<b>Application Ref:</b>	3/2025/0038			 <p>Ribble Valley Borough Council <a href="http://www.ribblevalley.gov.uk">www.ribblevalley.gov.uk</a></p>
<b>Date Inspected:</b>	14/03/2025	<b>Site Notice:</b>	14/03/2025	
<b>Officer:</b>	MC			
<b>DELEGATED ITEM FILE REPORT:</b>				<b>APPROVAL</b>

<b>Development Description:</b>	Proposed demolition of existing buildings and demolition of single-storey rear and side extensions to existing barn and conversion of barn to two dwellings with associated curtilage and parking areas.
<b>Site Address/Location:</b>	Units 3 3A 4 and 4A Cheetall Farm, Clitheroe Road, Bashall Eaves, BB7 3LH

EXISTING SITE PLAN

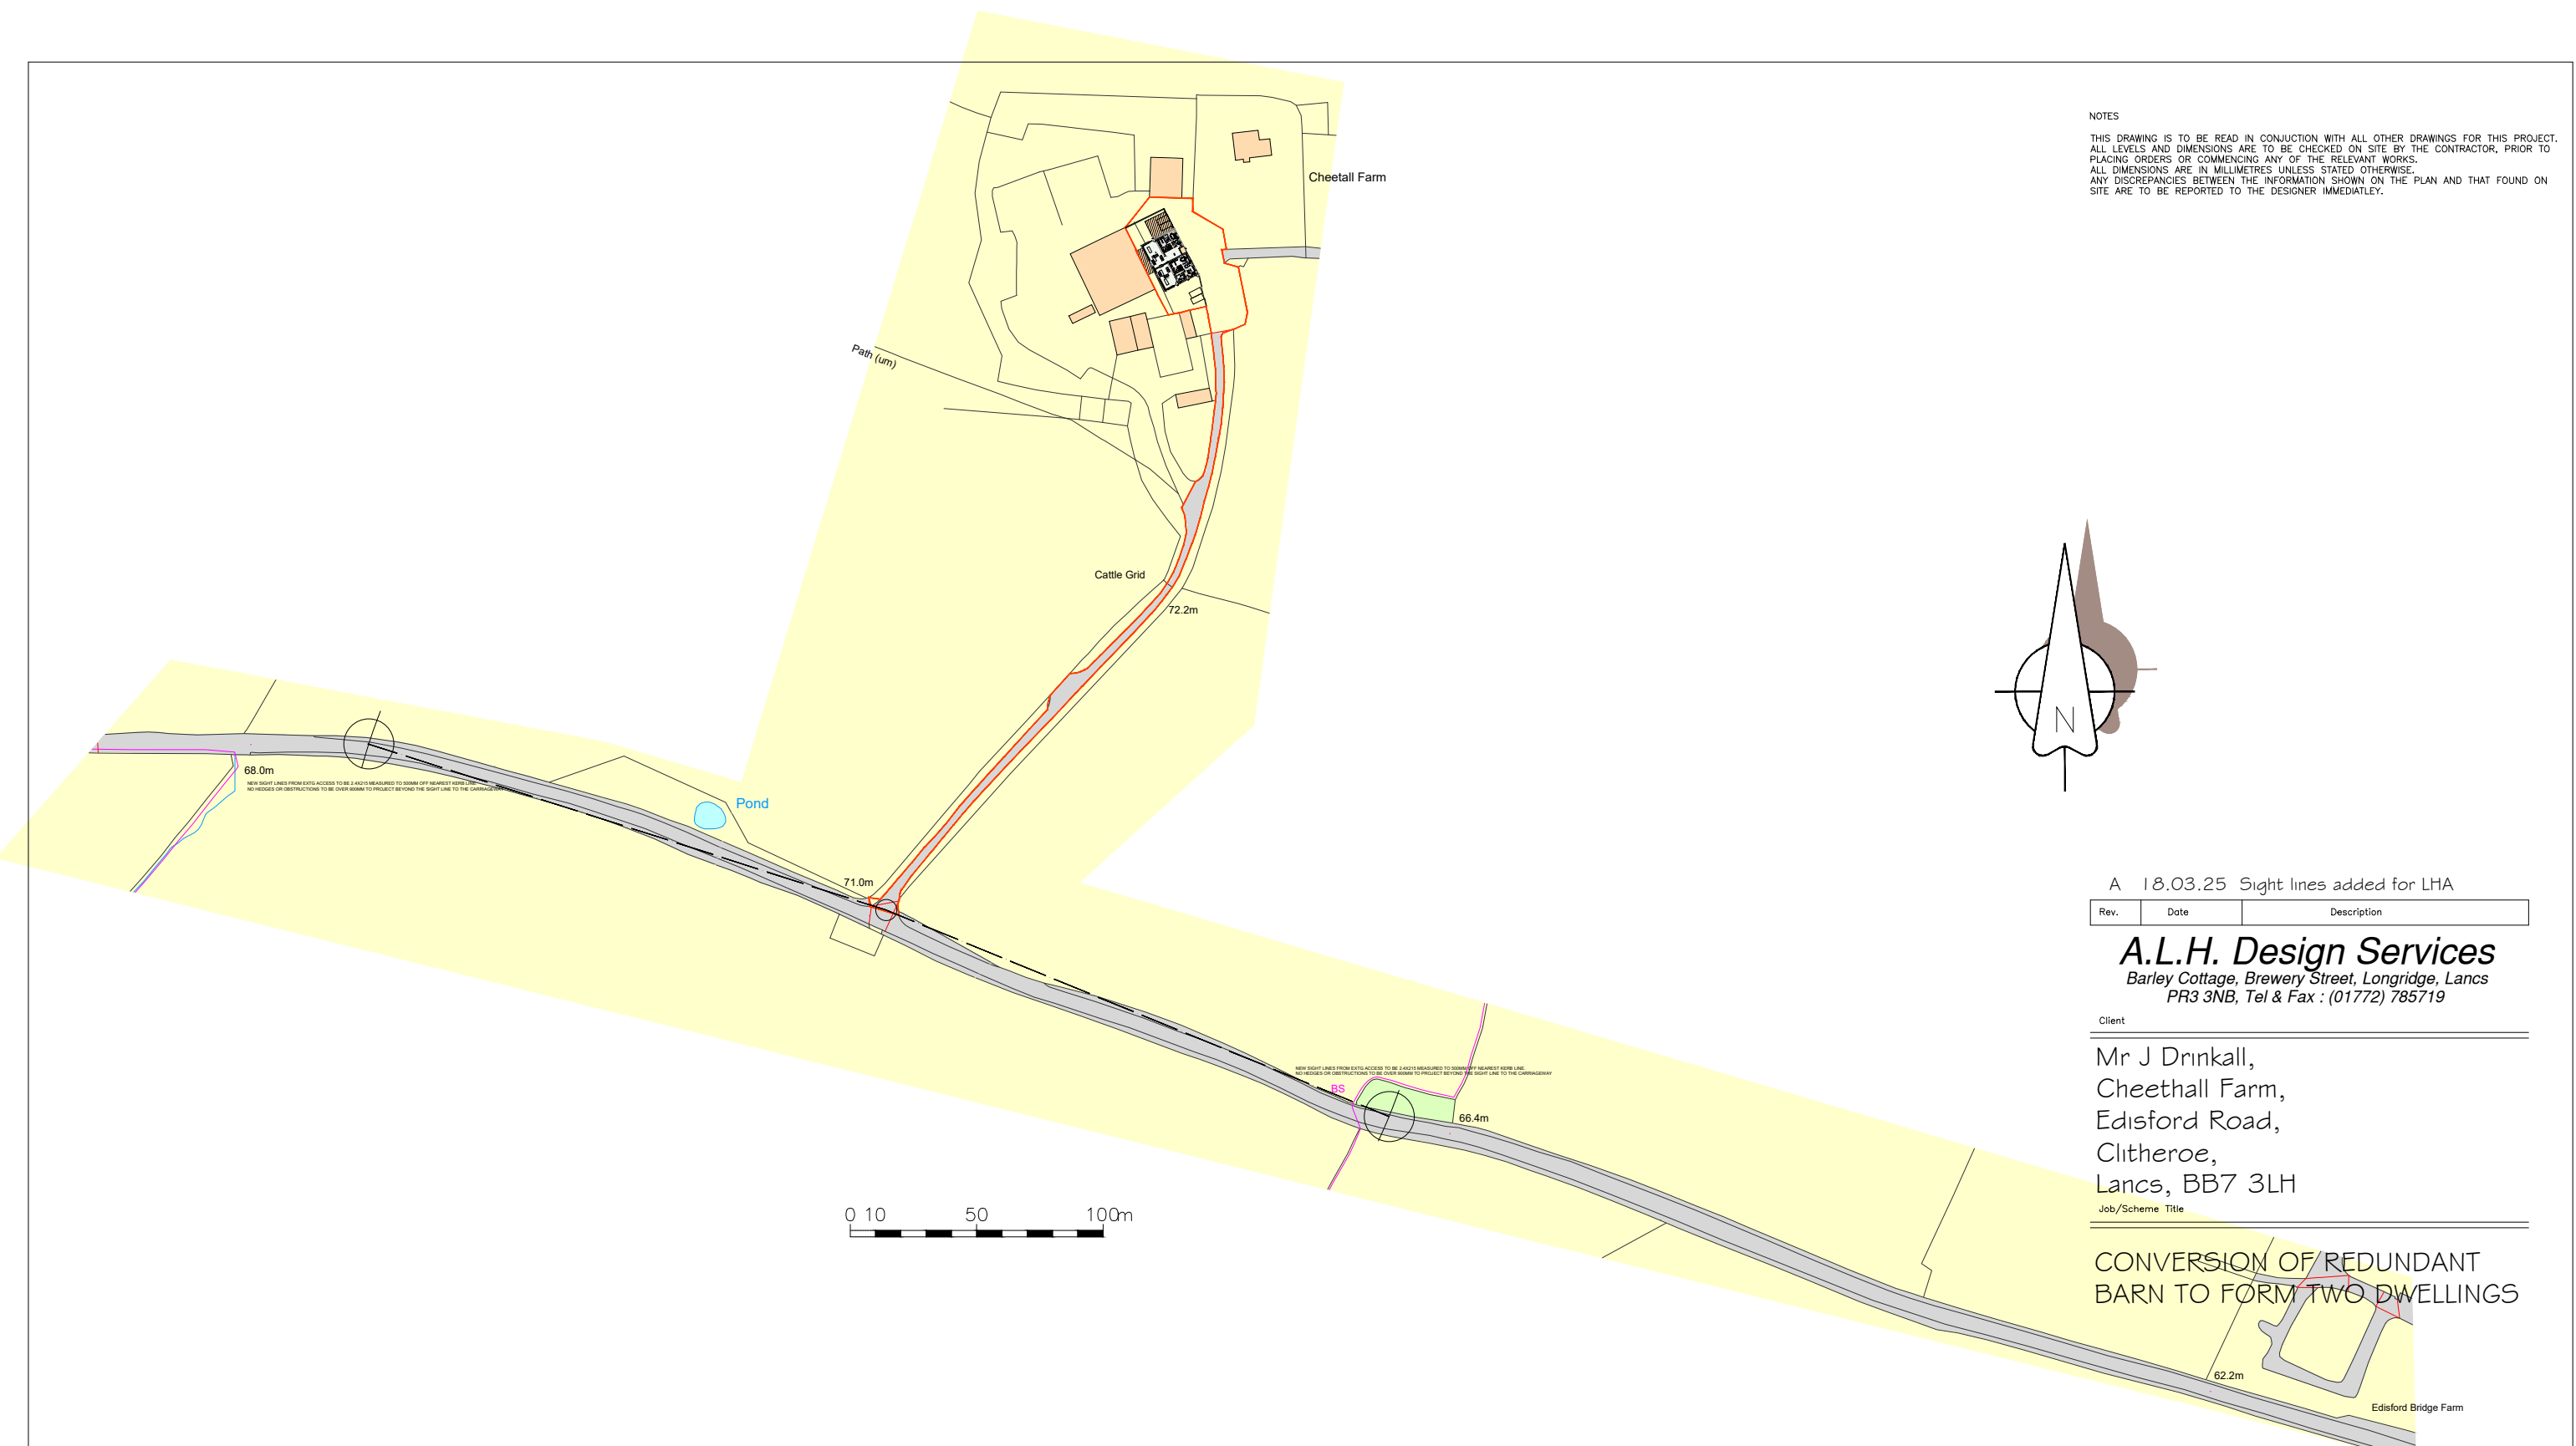
The Local Highway Authority have provided comments on the scheme. They are aware that the site access will remain unaltered following the proposal. They note that the access is at least 7m wide which is acceptable and whilst the private access track to the site is narrow there are 2 passing places along the track. The applicant has also provided a visibility splay within drawing No 0 1A showing visibility splays at the existing access, which meets Clitheroe Road. They recommend the inclusion of a condition so that no vegetation, walls or fences which fall within the visibility splay shall be above 0.9m above the carriageway level to ensure intervisibility between the access and Clitheroe Road and to ensure the appropriate visibility splays are provided first to first occupancy/use.

PROPOSED ROOF PLAN

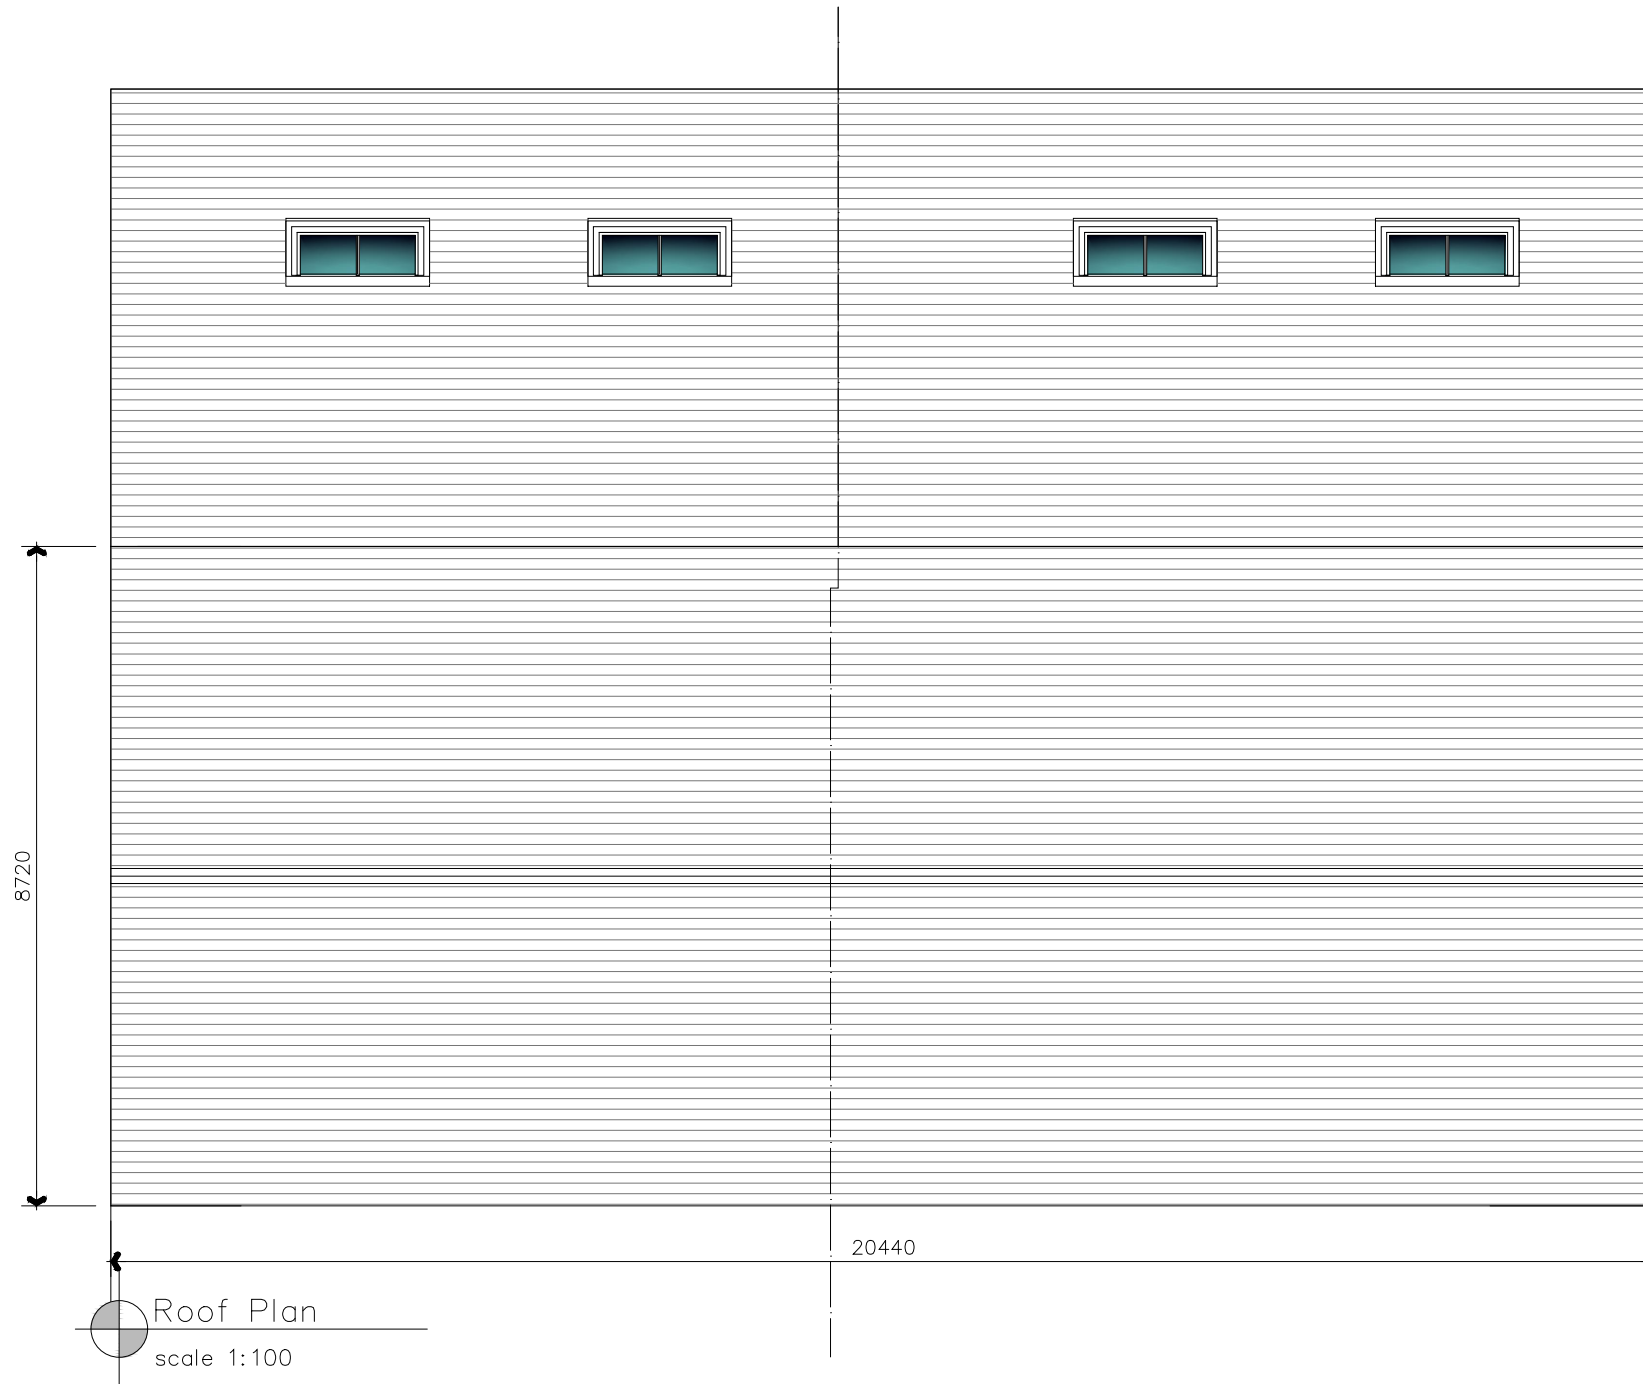
In this instance, the original design concept of the proposed development included the introduction of several new window openings, with the fenestration proposed in a somewhat regimented configuration which was not considered to be reflective of the more random sequence of openings typically seen within historic agricultural buildings. The scheme has now been amended and the amount of doors/windows reduced to reflect the typical random sequence of openings. In addition, to the rear catslide roof, large rooflights were proposed which were not considered to be in keeping with the agricultural character of the barn. Although these are on a lower roof slope, the rooflights have also now been reduced in width which is considered to be more appropriate.

Additional works proposed include the infilling of the barn owl openings with glazing and the replacement of the fibre cement roof profiled sheeting with slates which are considered acceptable subject to a sample of materials condition. Furthermore, no extensions to the footprint or height of the barn are proposed as part of the conversion. As such, the proposed scheme of residential conversion would be largely respectful to the historic character of the barn building.

Drawing Title
PROPOSED SITE PLAN

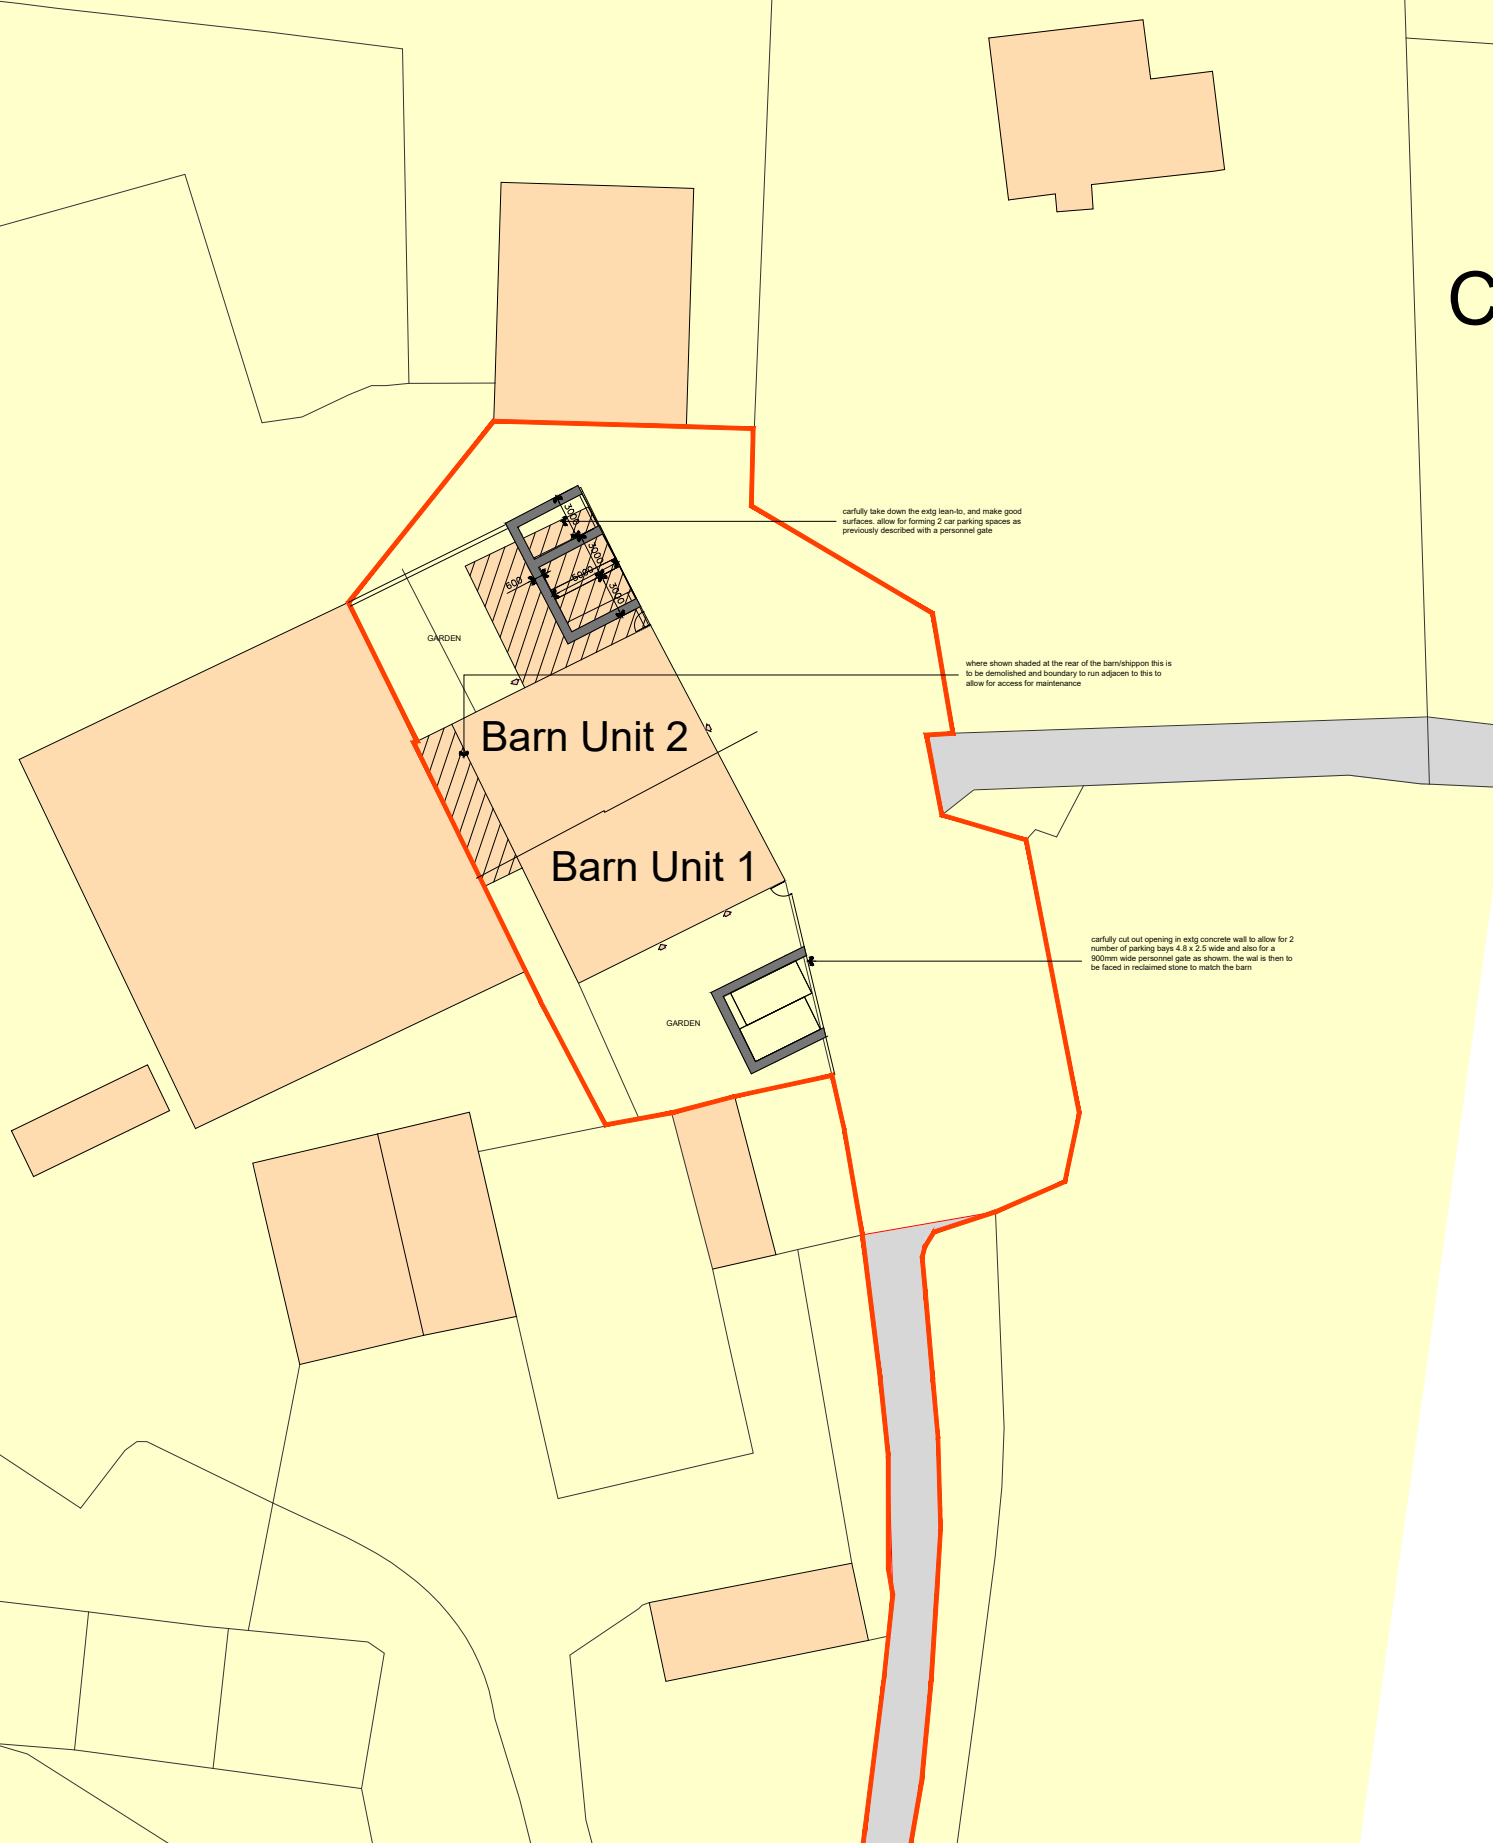
Planning consent is sought for the conversion of the existing barn to two residential units. This would involve the demolition of an existing single storey side and rear extensions to facilitate the development, as well as the adjacent buildings labelled 'Building A', 'Building B' and 'Building C' on drawing ref: 0 8 A.

The existing extensions to the barn to be converted are to be removed and made good to allow for two parking spaces for unit 2 and for unit 1, the existing concrete wall would be cut out to allow for an additional 2 no. parking spaces. The wall would be faced in reclaimed stone to match the existing barn which is considered acceptable. It is considered that the size of the curtilages are acceptable and would not result in any significant encroachment into the countryside. In addition, a landscaping plan can be secured by way of condition to ensure that the land is appropriately landscaped following the demolition of the existing buildings. Boundary treatments can also be secured by way of planning condition for the residential curtilages.

They note 2 no. off street parking spaces would be provided for unit 1 which is acceptable. They have stated that 3no. parking spaces will be provided for unit 2 which is not correct and 2 no. parking spaces would be provided. However, given this unit has the same amount of bedrooms as Unit 1, this would not warrant refusal of the application.
